**El Paso County
Planning & Community Development**
2880 International Circle, Suite 110
Colorado Springs, CO 80910-3127
Attn: Len Kendall

February 4, 2019

**RE: Woodmen Hills Metropolitan District
Lift Station #1 Replacement
Site Development Plan (PPR1841) – Comment Response Letter**

C14  
SHEET 14 OF 19

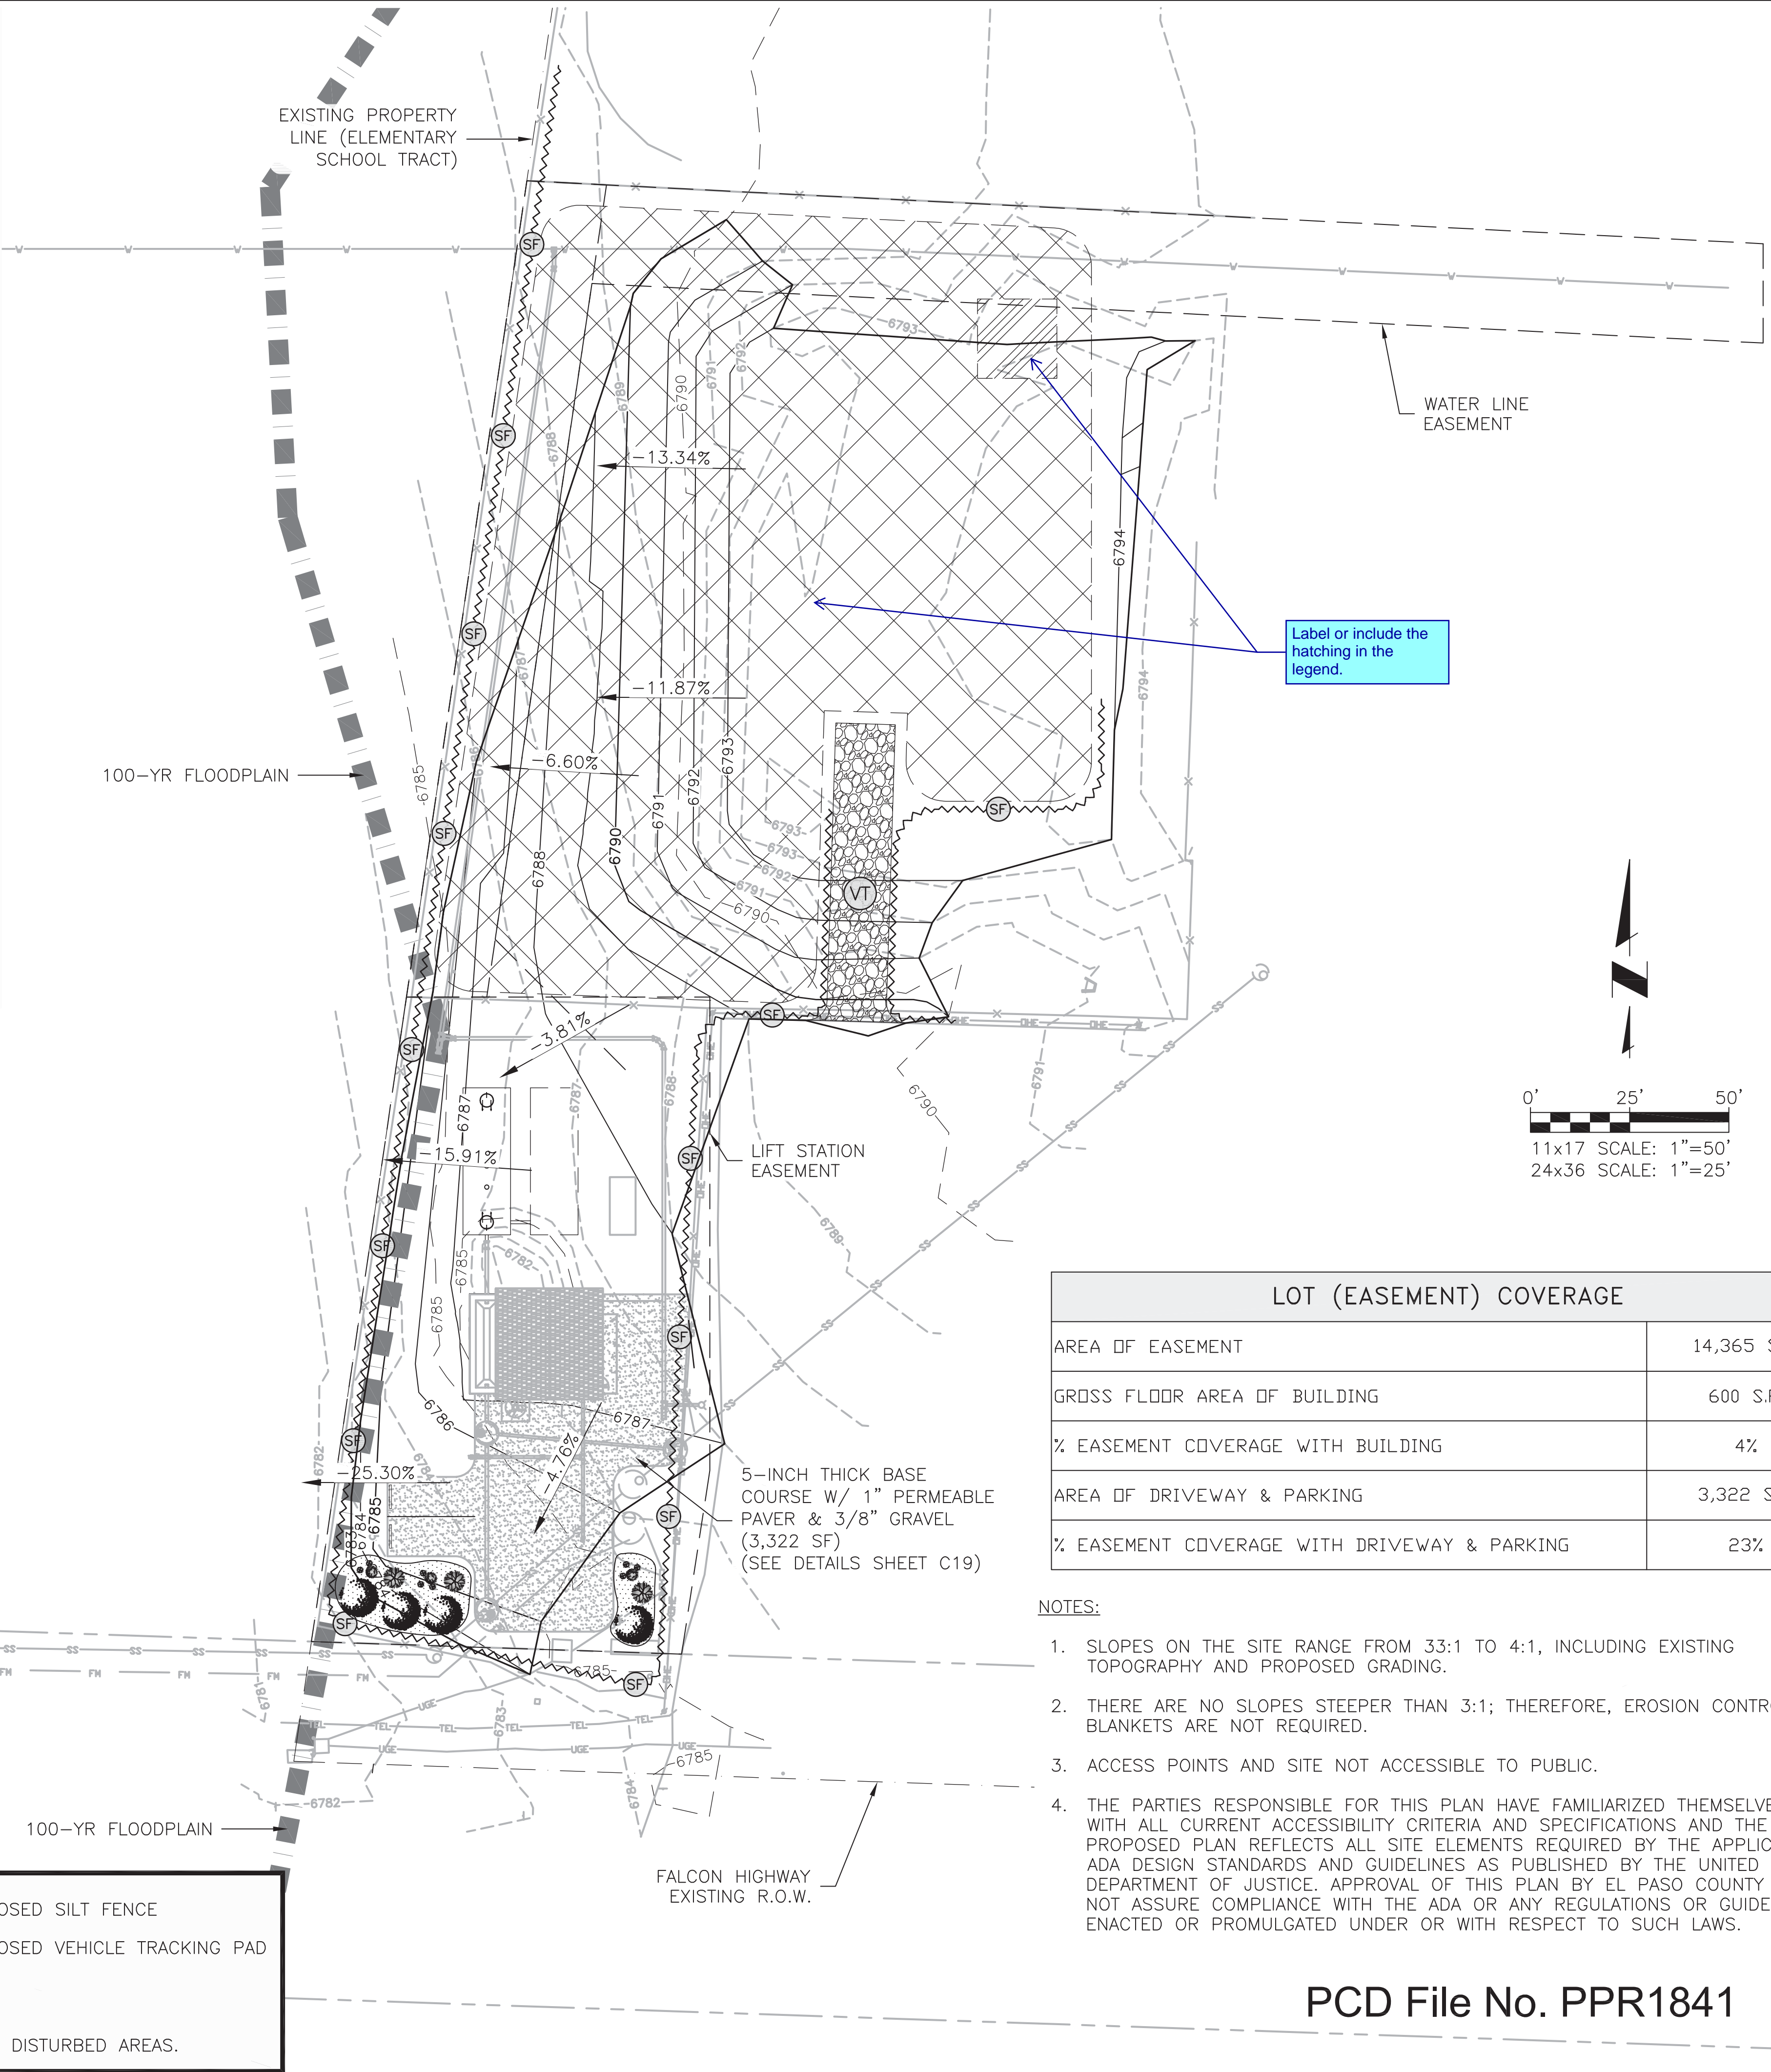
3. Very small portion of site has 100 floodplain. Should not affect this project.
Correct. Mapping of the 100-yr floodplain via GIS software shows it outside of all proposed improvements, and none of the grading for the new facility will be done inside the floodplain.
